**Consultation Response from Mark Berry KC,
Highways Development Management**

2021/93585 Land at, Whitechapel Road, Cleckheaton

**Discharge of condition 16 (retaining walls/structures) of previous permission 2019/93658 for
erection of 122 dwellings, landscaping and associated infrastructure**

RETAINING WALL SECTIONS

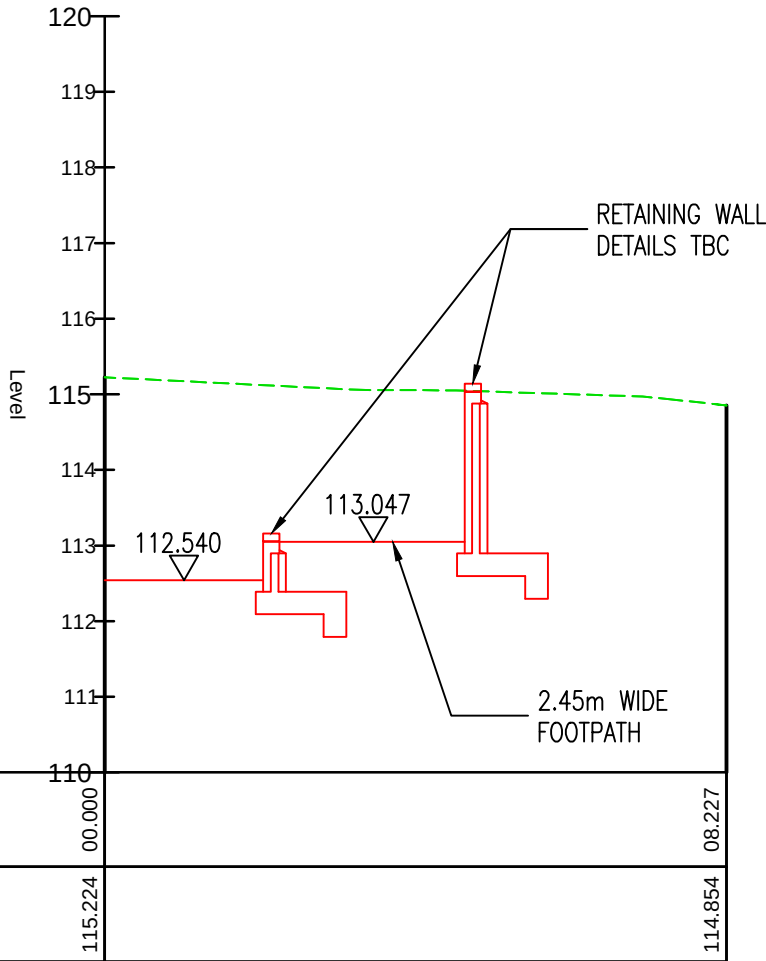
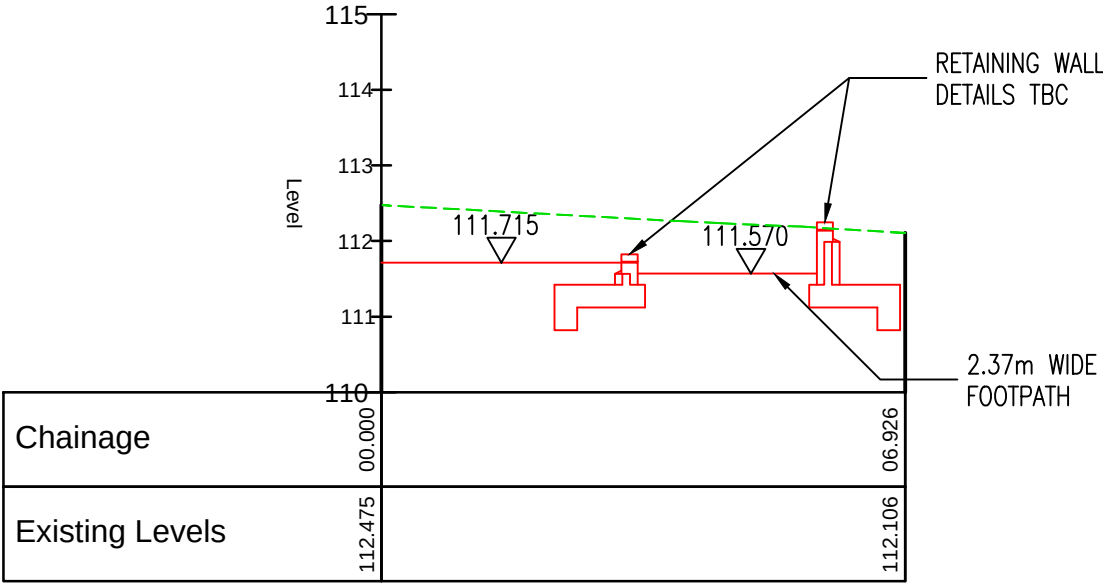
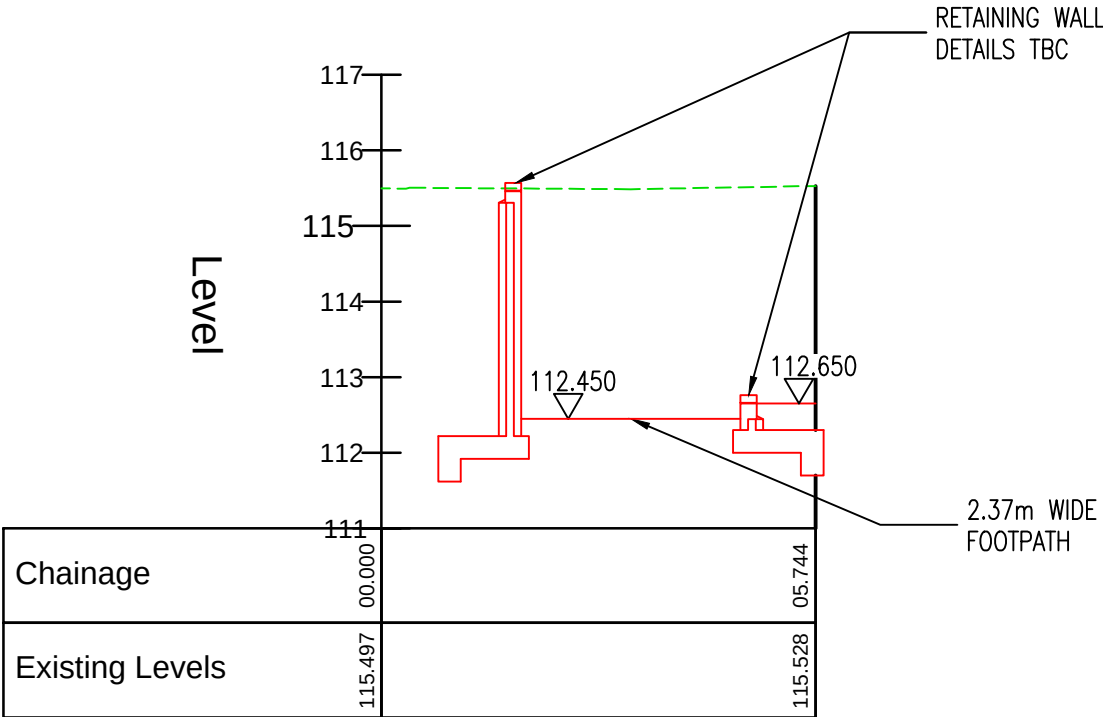
These proposals will require a separate formal Technical Approval by the Council's Highways Structures Section. Please Contact Farhad Khatibi (Design Team Leader) to discuss the level of detailed structural information required for submission to commence this process. Please note that there will be an additional fee payable in lieu of the design approval process by the Structure's section.

Highways Structures section confirm that the technical approval for the design of new retaining walls at this site have not yet commenced.

This condition should not therefore be discharged.
